COLORADO GEOLOGICAL SURVEY

December 20, 2024

**Subject: Fishers Canyon Final Plat Multi-Family;
El Paso County, CO;
County File No SF243; CGS Unique No. EP-25-0022**

**VENTURE ON VENETUCCI
 EL PASO COUNTY, COLORADO
 CONSTRUCTION DOCUMENTS
 EXISTING CONDITIONS AND DEMOLITION PLAN**

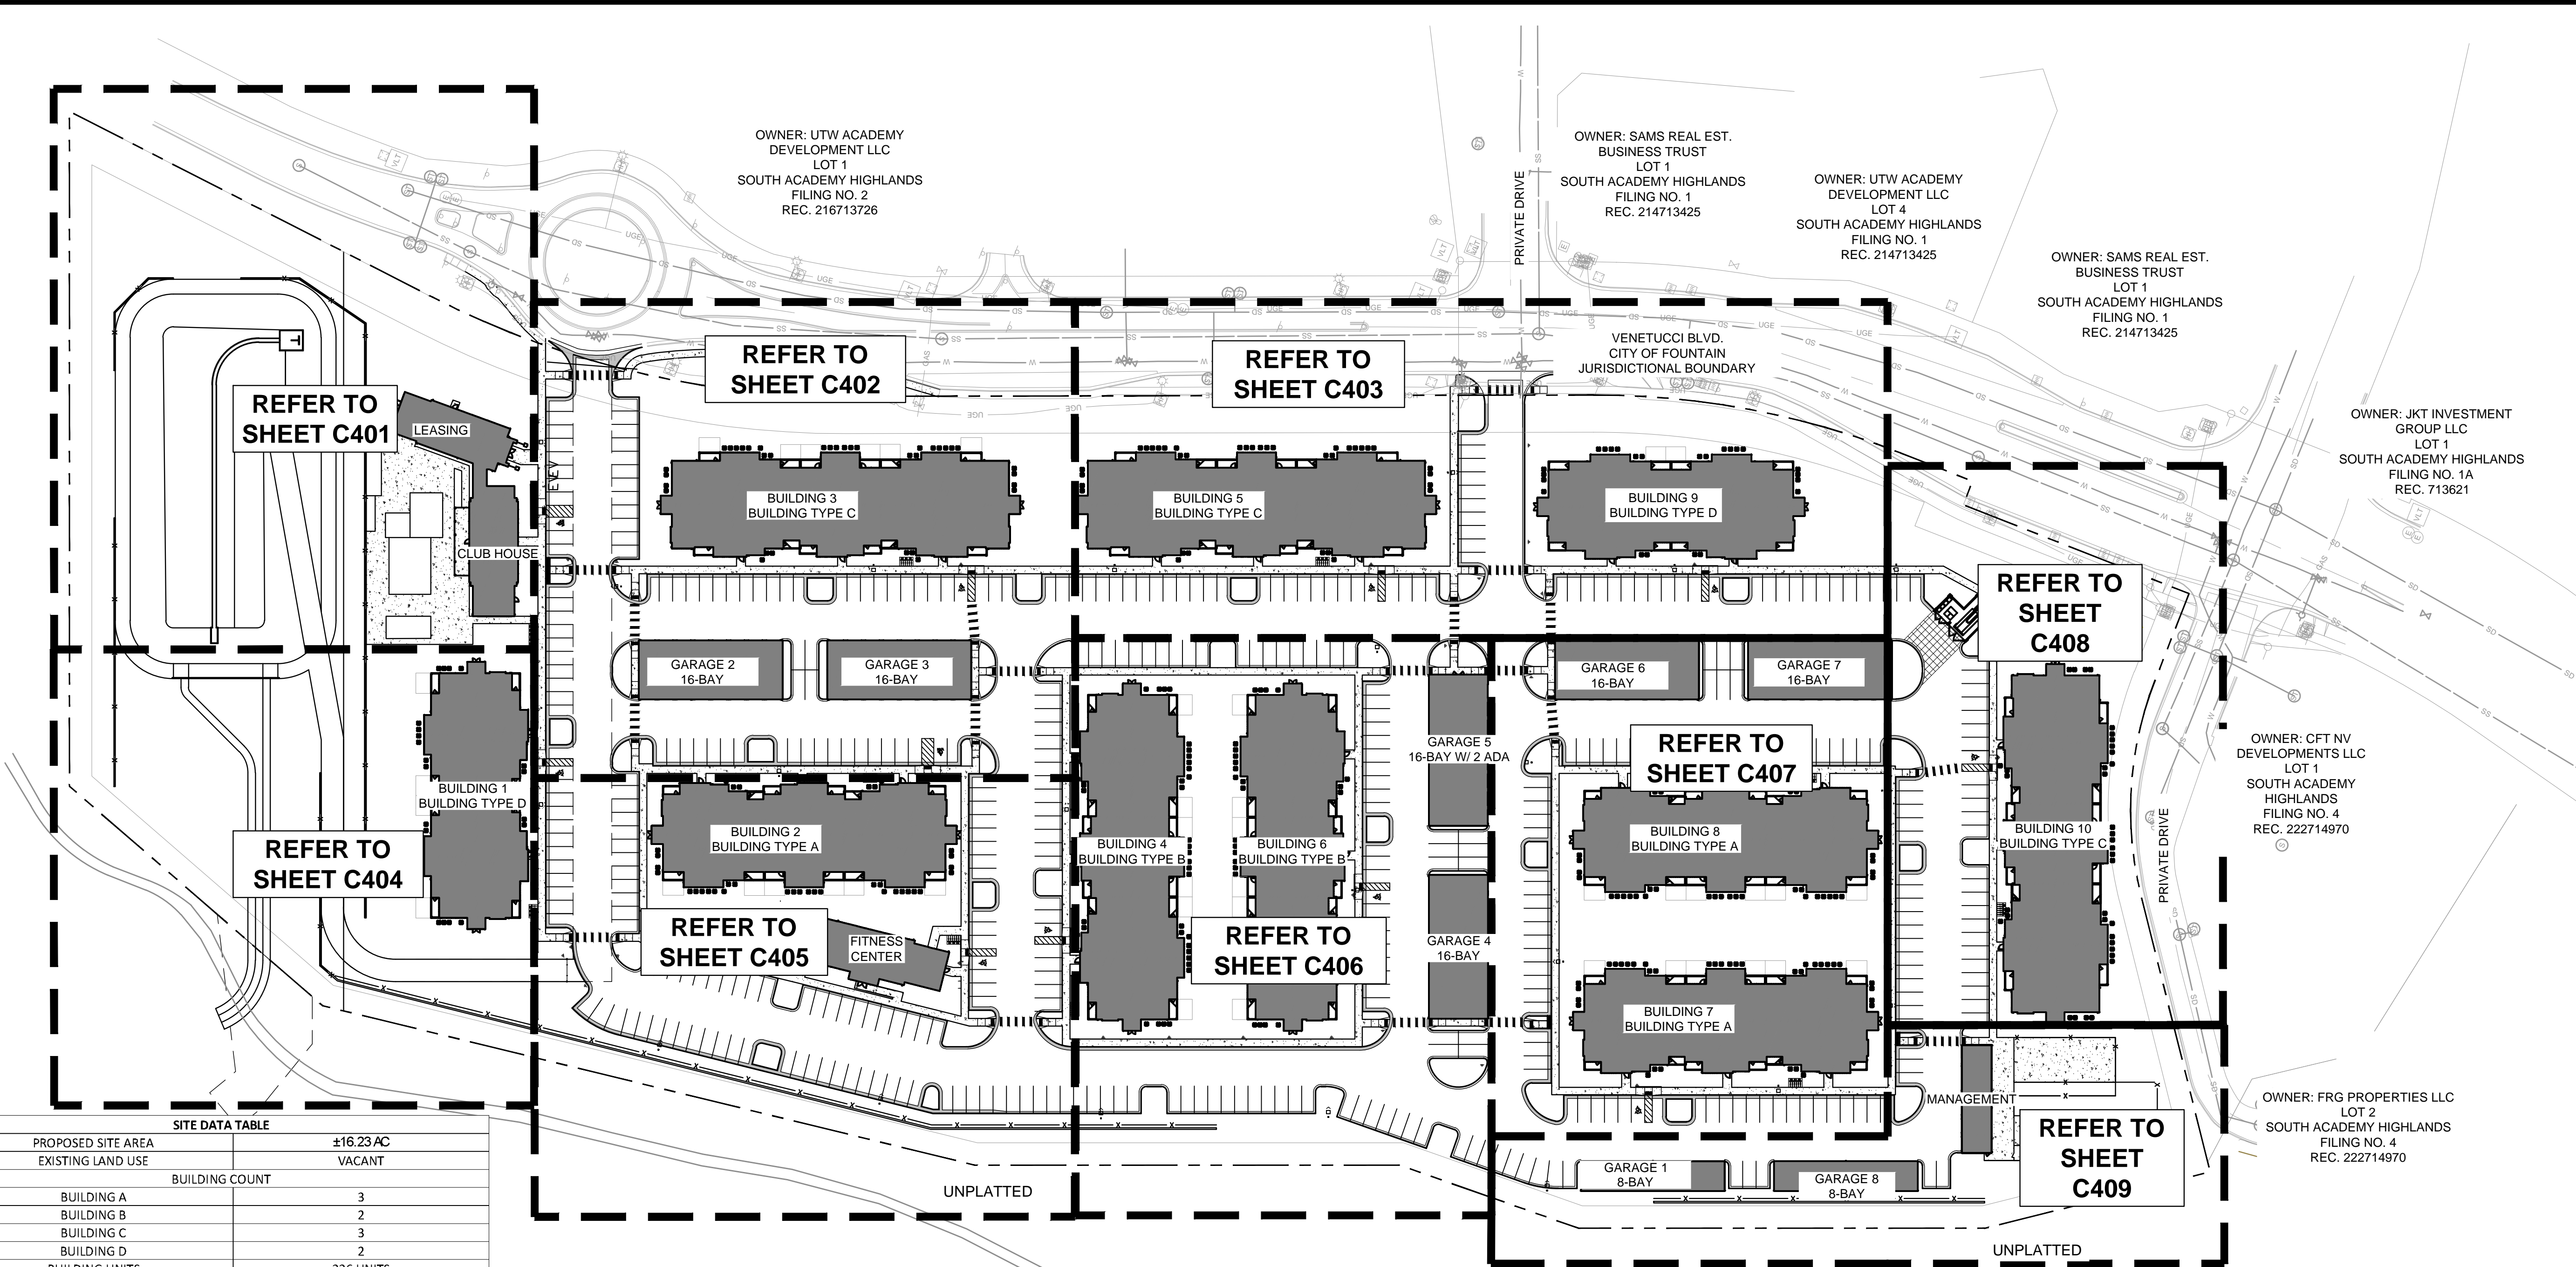
- **Drainage Considerations:** Clarify how water from historic groundwater flow will drain from the former valley now infilled, where the existing drainpipe will be removed (Existing Conditions Sheet C200).
